**WEST SUSSEX COUNTY COUNCIL
INFRASTRUCTURE CONSULTATION**

SUBJECT: BR/244/10 - Proposed single storey extension

36-38, Sudley Road, Bognor Regis, West Sussex, PO21 1ER

Proposed Ground Floor
Scale 1:100

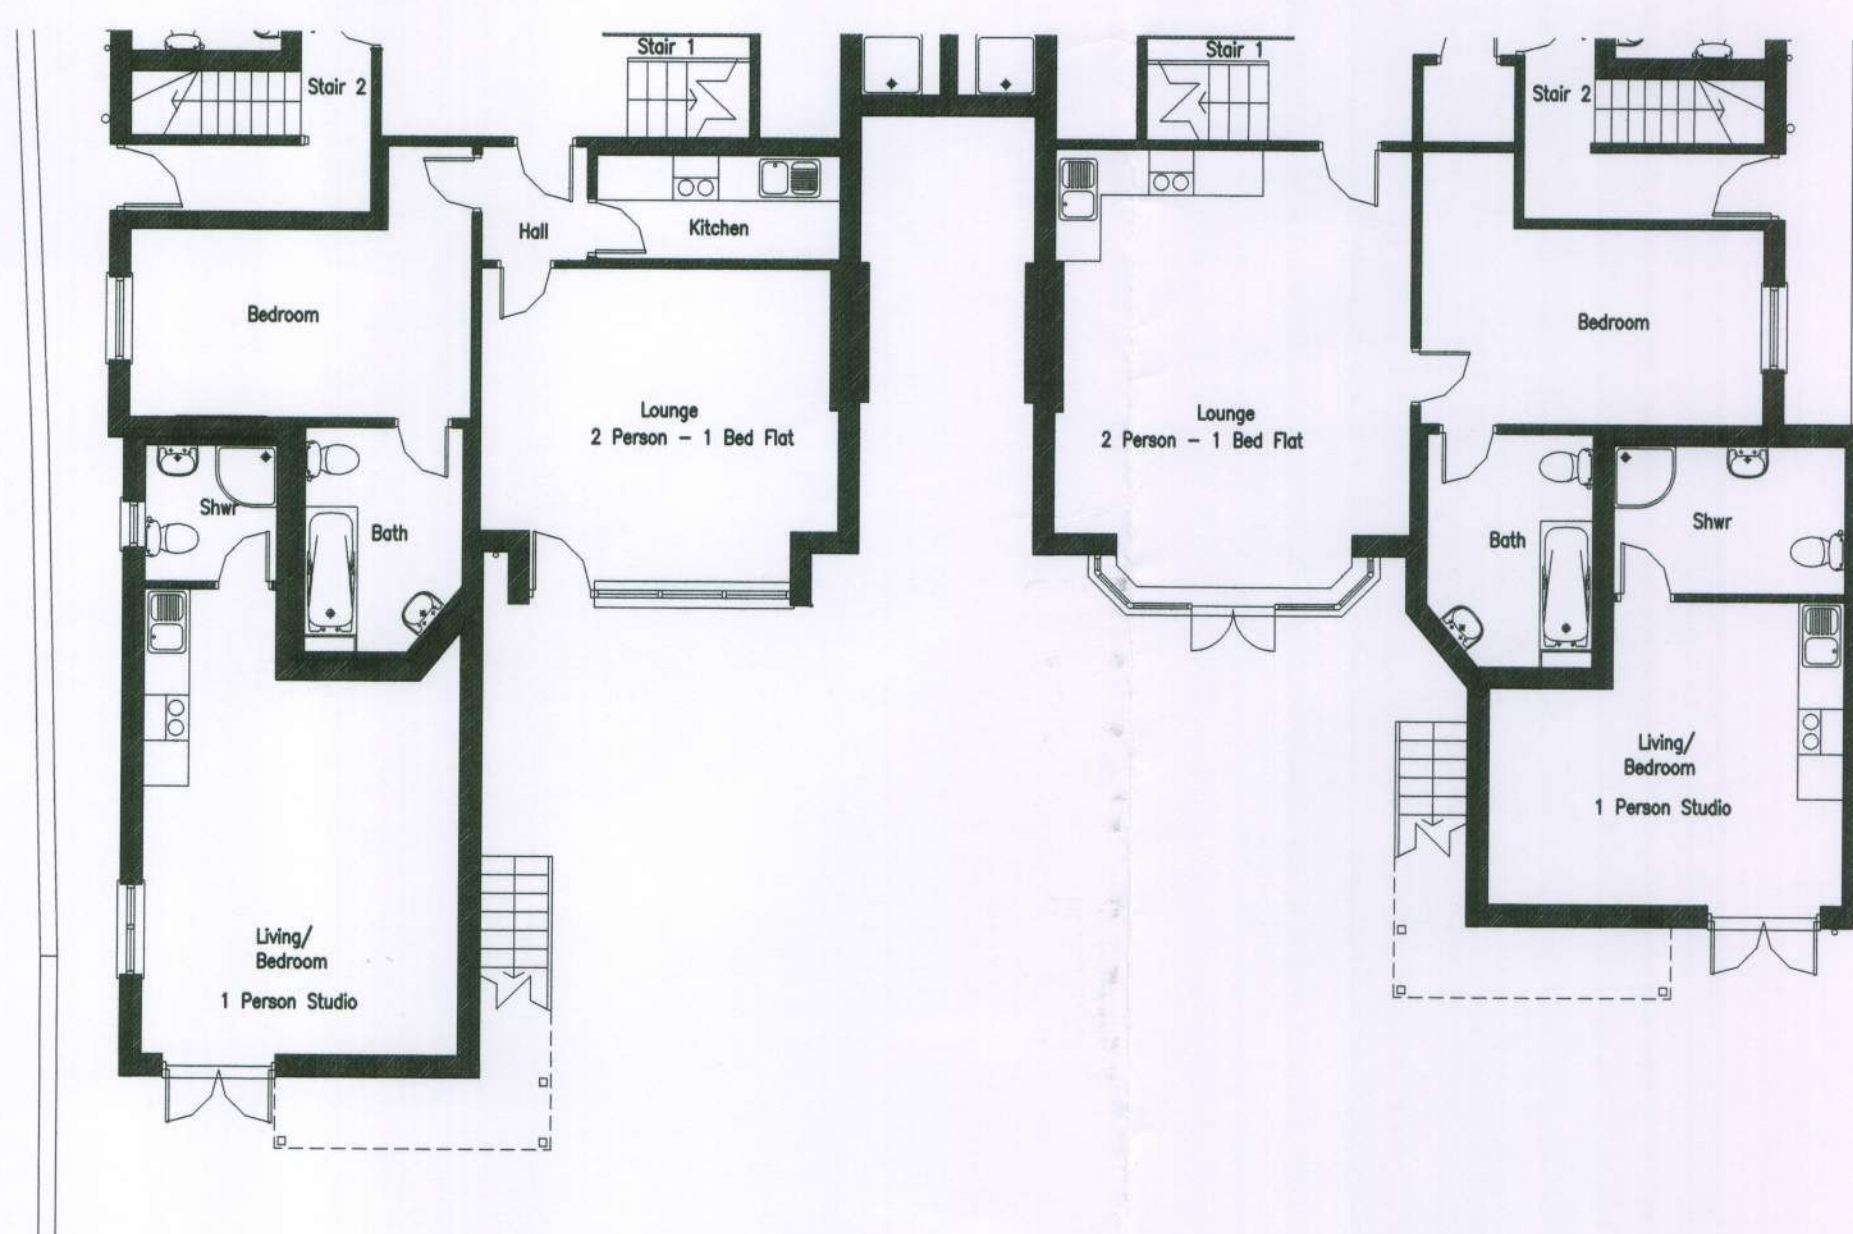
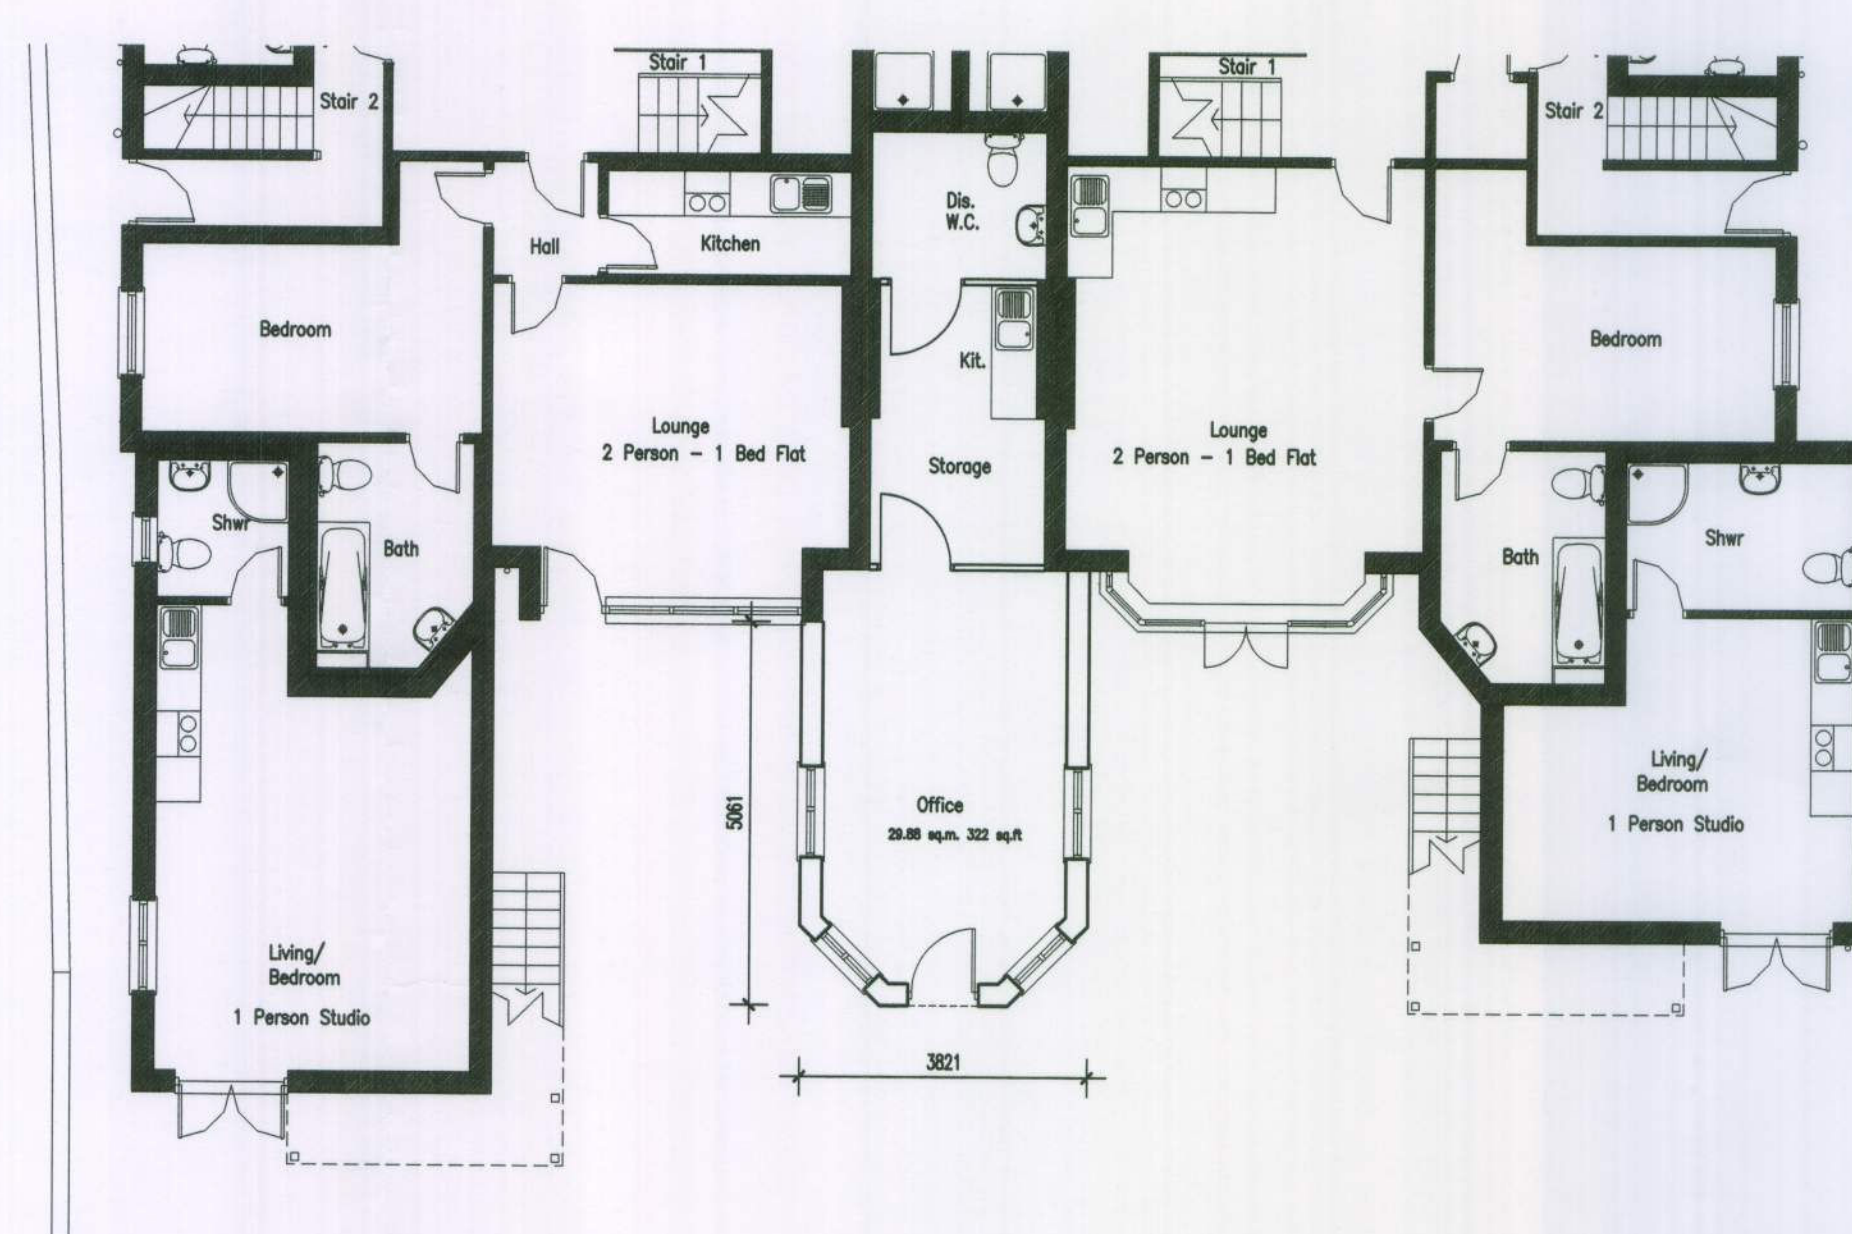
It appears from the plan that the extension may result in the loss of an off-street parking space within the site. However, in terms of transport the property is situated in a sustainable location. The property is within walking distance of a range of services and public transport, hence there is no reliance as such on the use of the private car. Secure and covered cycle parking should be available for staff as well as residents and visitors.

If the LPA are minded to approve this application, a condition securing cycle parking should be included.
